Application No: FP/94/20/HH
Site Address: 16 Westmorland Drive Felpham PO22 8LX
Description of works: Removal of existing side porch & rear conservatory & erection of single storey side & rear extension.

Thank you for your internet representation made on 17th July 2020 which has been recorded as an objection with the comments as follows:

PROPOSED SINGLE STOREY EXTENSION AT 16, WESTMORLAND DRIVE, FELPHAM
FOR MR. & MRS. D. MILLIER.

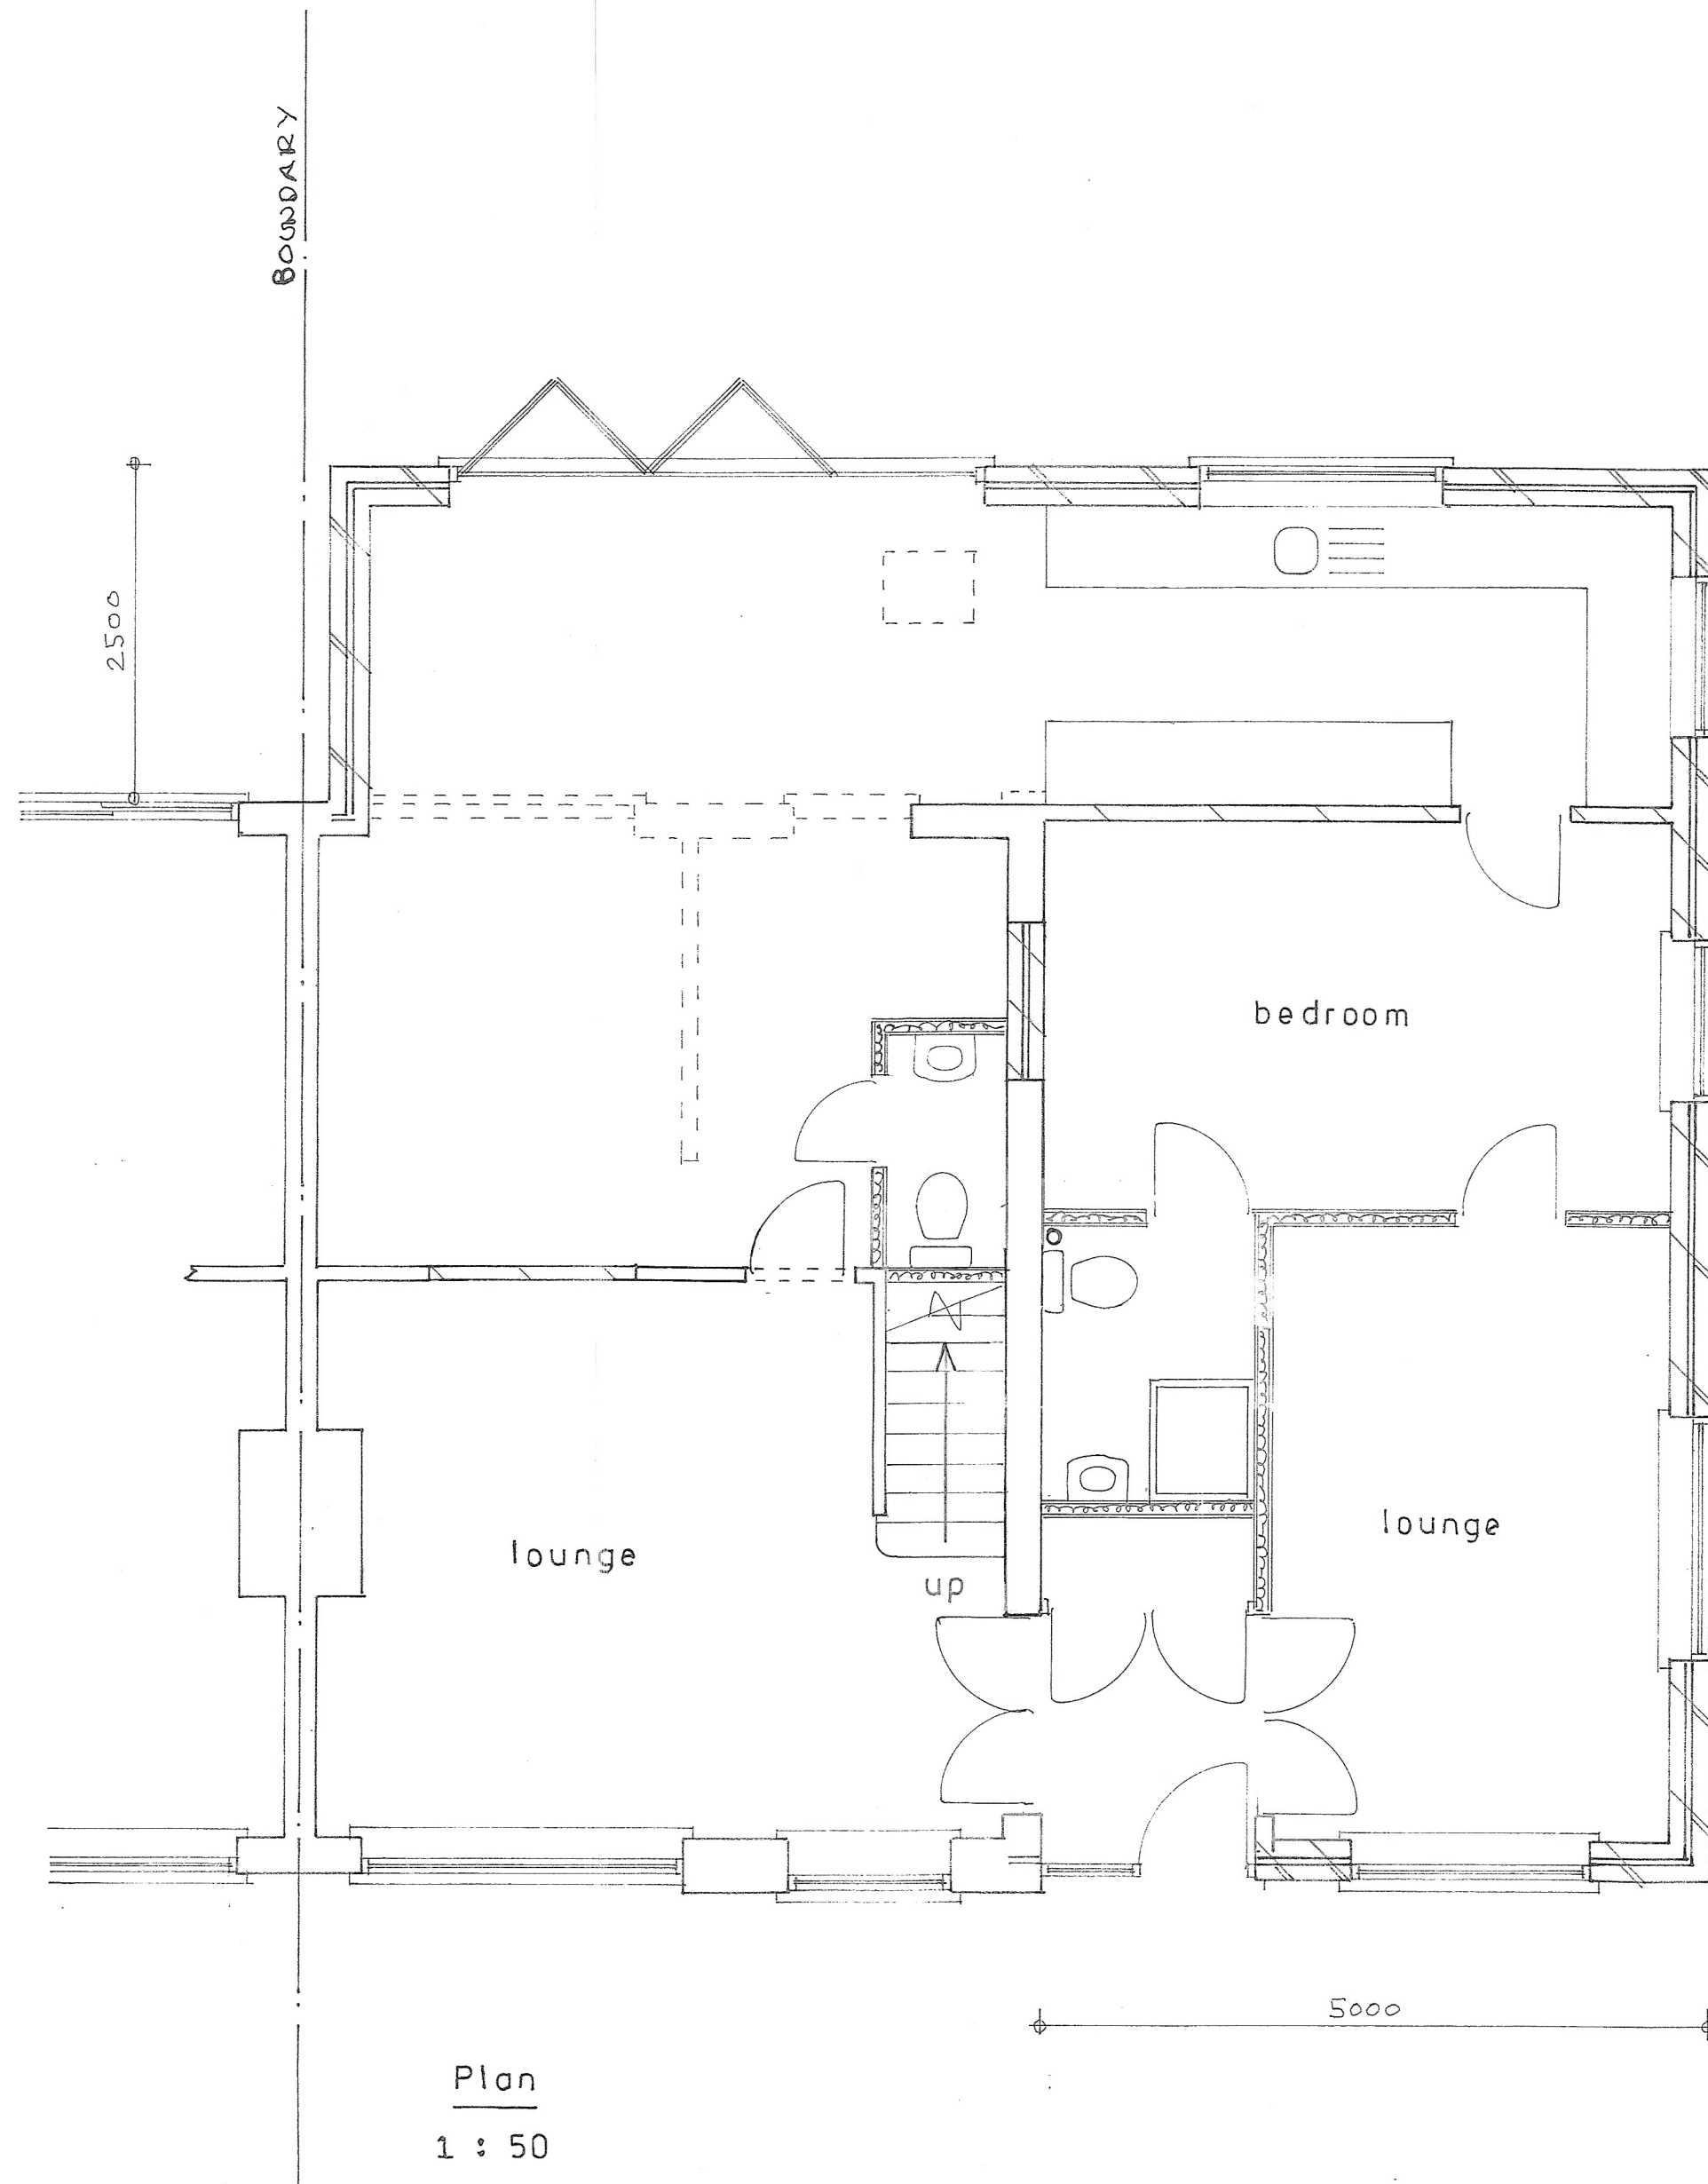
My property is in Derwent Grove and is attached to the property at 16 Westmoreland Drive.
My concerns are the construction of the 1 storey extension to the rear of the property and the height of the roof. Will this impact on the light into my living room and the overshadowing to the rear garden.
Also if the intention is to move the main entrance to the property, do they intend to change the registered address to Derwent Grove or will it remain the same.
Parking is an issue in Derwent Grove, my property is at the entrance to the road and it can sometimes be difficult to park, I do have a driveway which has space for a single car. Does the owner intend to move their off road parking which is currently to the rear of their property, to the front, this will reduce the parking spaces in Derwent Grove if the intention is to place a drop kerb and off road parking at the new front entrance to their property.
